From: Amanda Scholes on behalf of Planning.Responses
Sent: 12 March 2018 09:29
To: Planning Scanning
Subject: FW: 12 Raleigh Road

From: Mark Jones
Sent: 26 February 2018 12:08
To: 'Gary Smith'
Subject: RE: 12 Raleigh Road

Can you confirm if the new roof over the garage at No.10 is part of the current application.

Proposed Garage and Utility room. 12 Raleigh Road, Bognor Regis, West Sussex.
Proposed Ground Floor and Roof Plan. Drawing Number = 10 Scale 1:100 @ A3

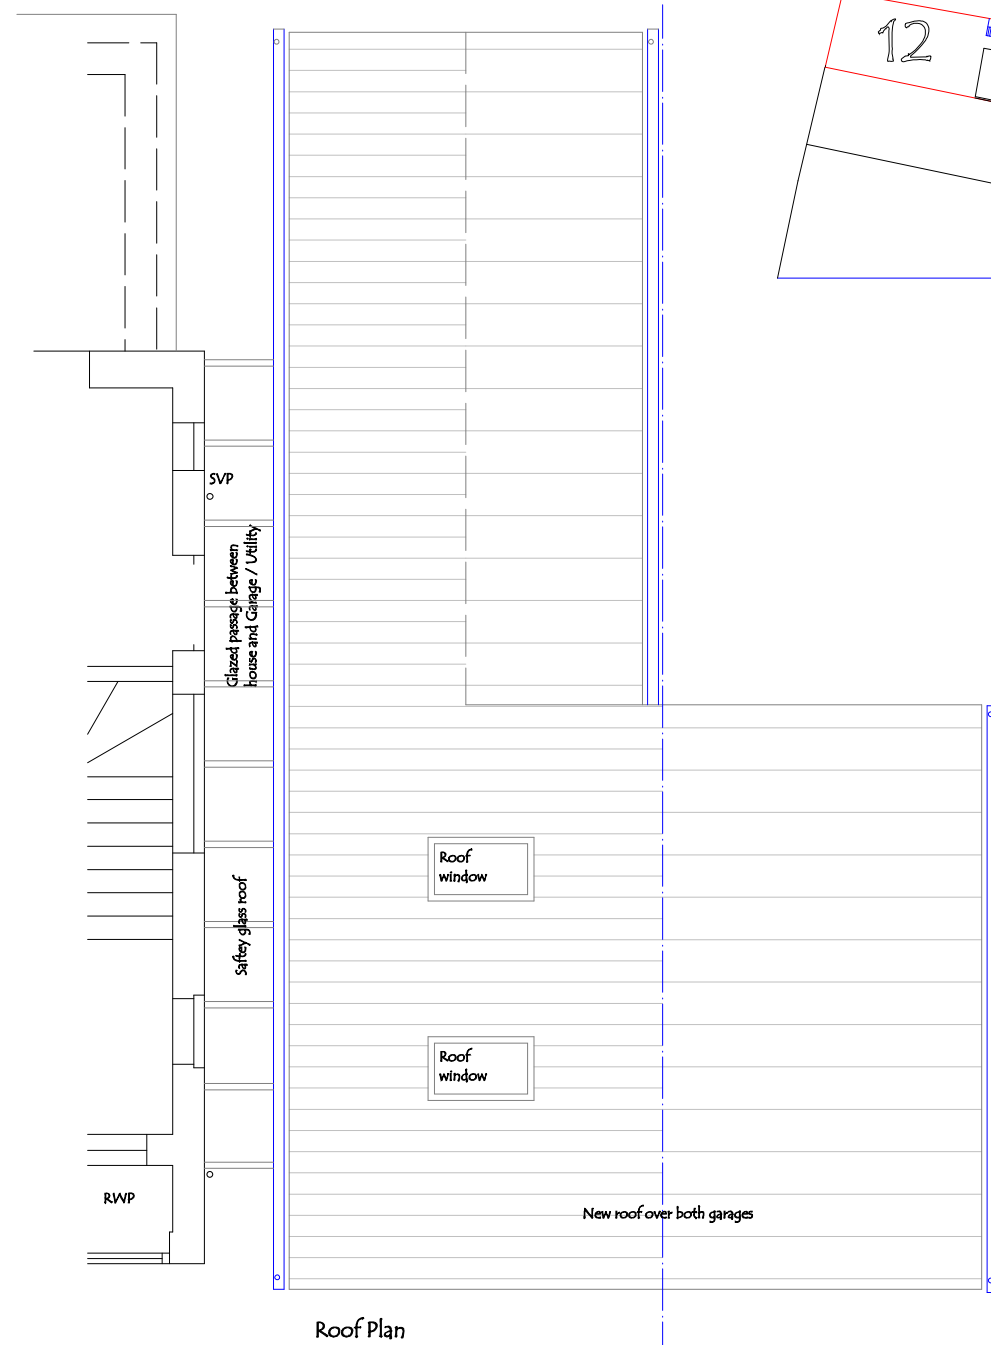
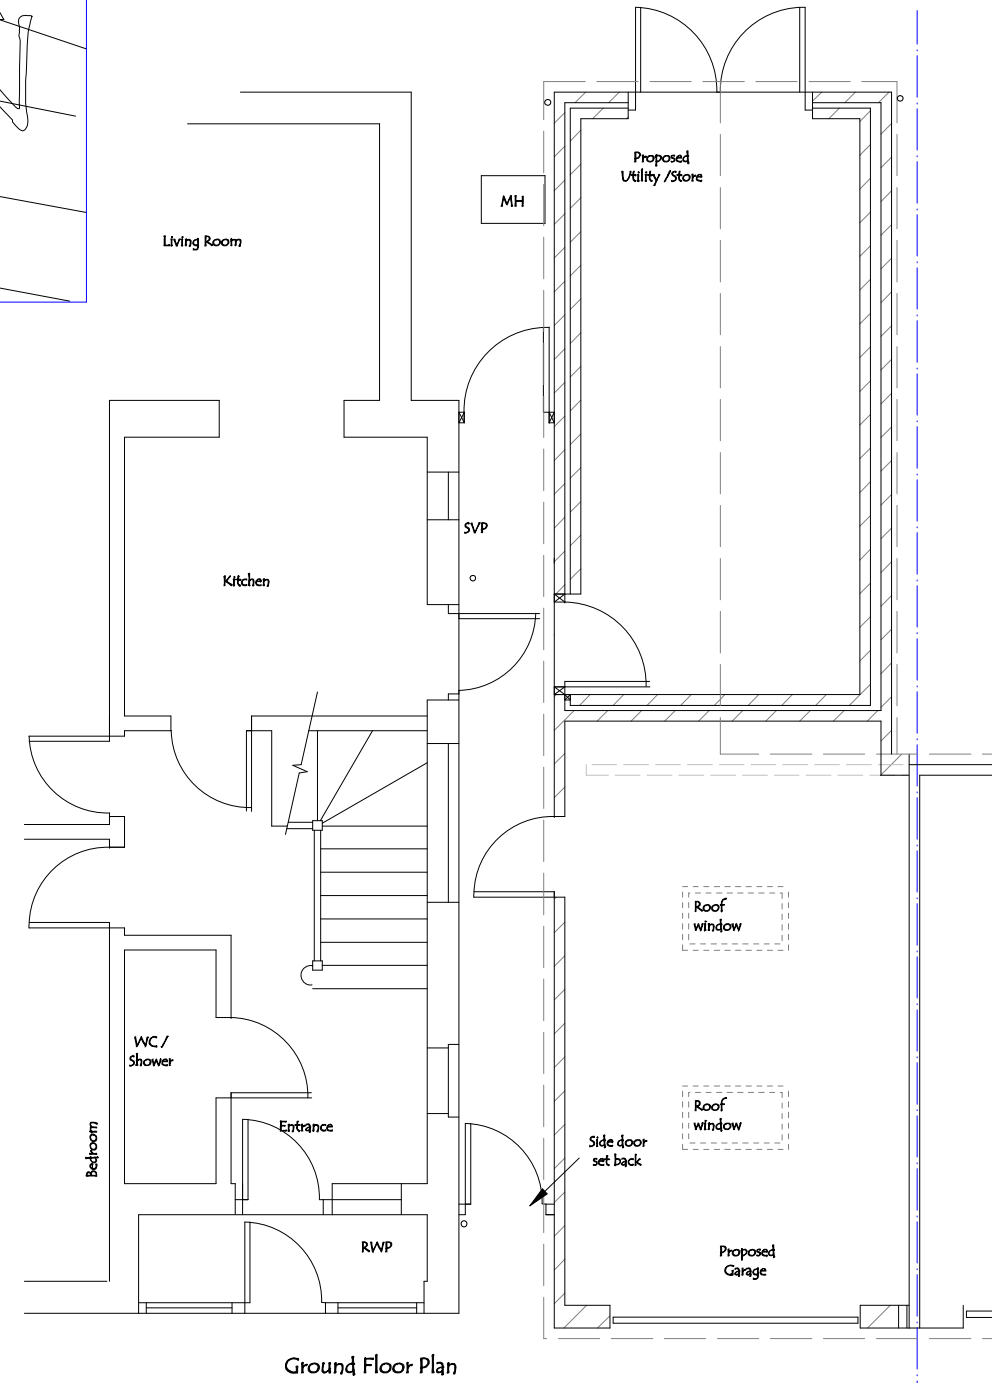
1. The plans are amended to remove the proposed roof on the neighbouring property No.10 and make a separate application for No.10 or leave No.10 out of consideration.

Proposed Garage and Utility room. 12 Raleigh Road, Bognor Regis, West Sussex
Proposed Elevations. Drawing Number = 11 Scale 1:100 @ A4

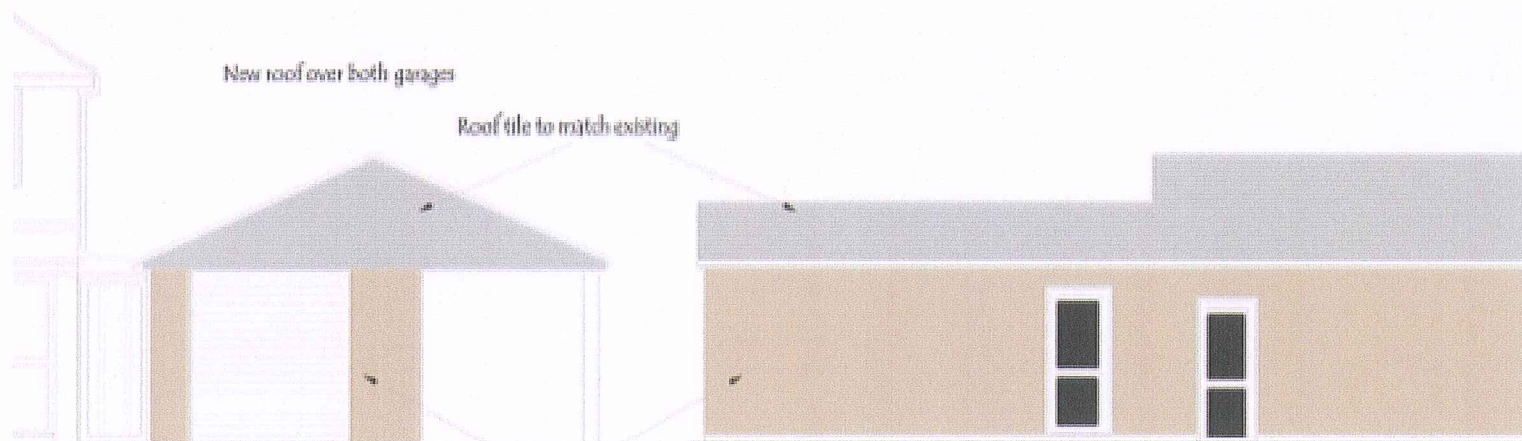
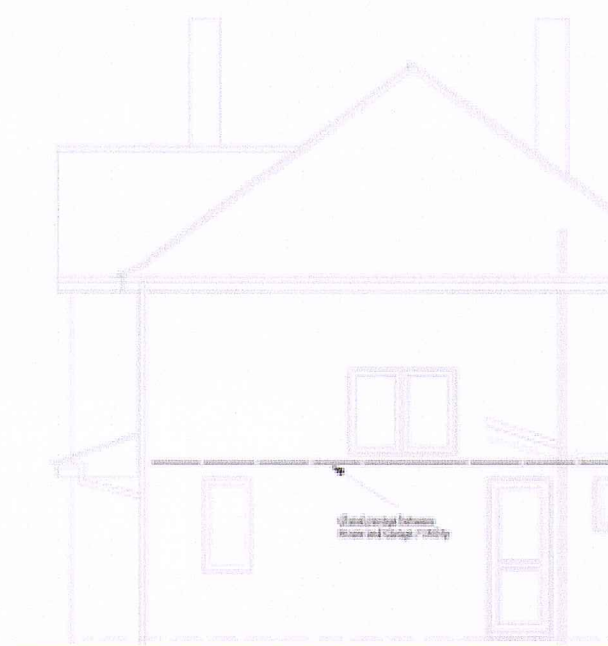
2. The application form changed to reflect 10 and 12 including the description . In addition the red line would need to change on location plan to include No.10. Also certificate B would be required if the application is in your name and notice served on the owner of No.10, as mentioned these forms can be obtained on the planning portal. We would need to agree an extension of time for the application to allow a revised application to be re advertised.

The roof at no. 10 is currently flat.

We are proposing a pitched roof across both properties in the application to enhance the appearance of both properties.
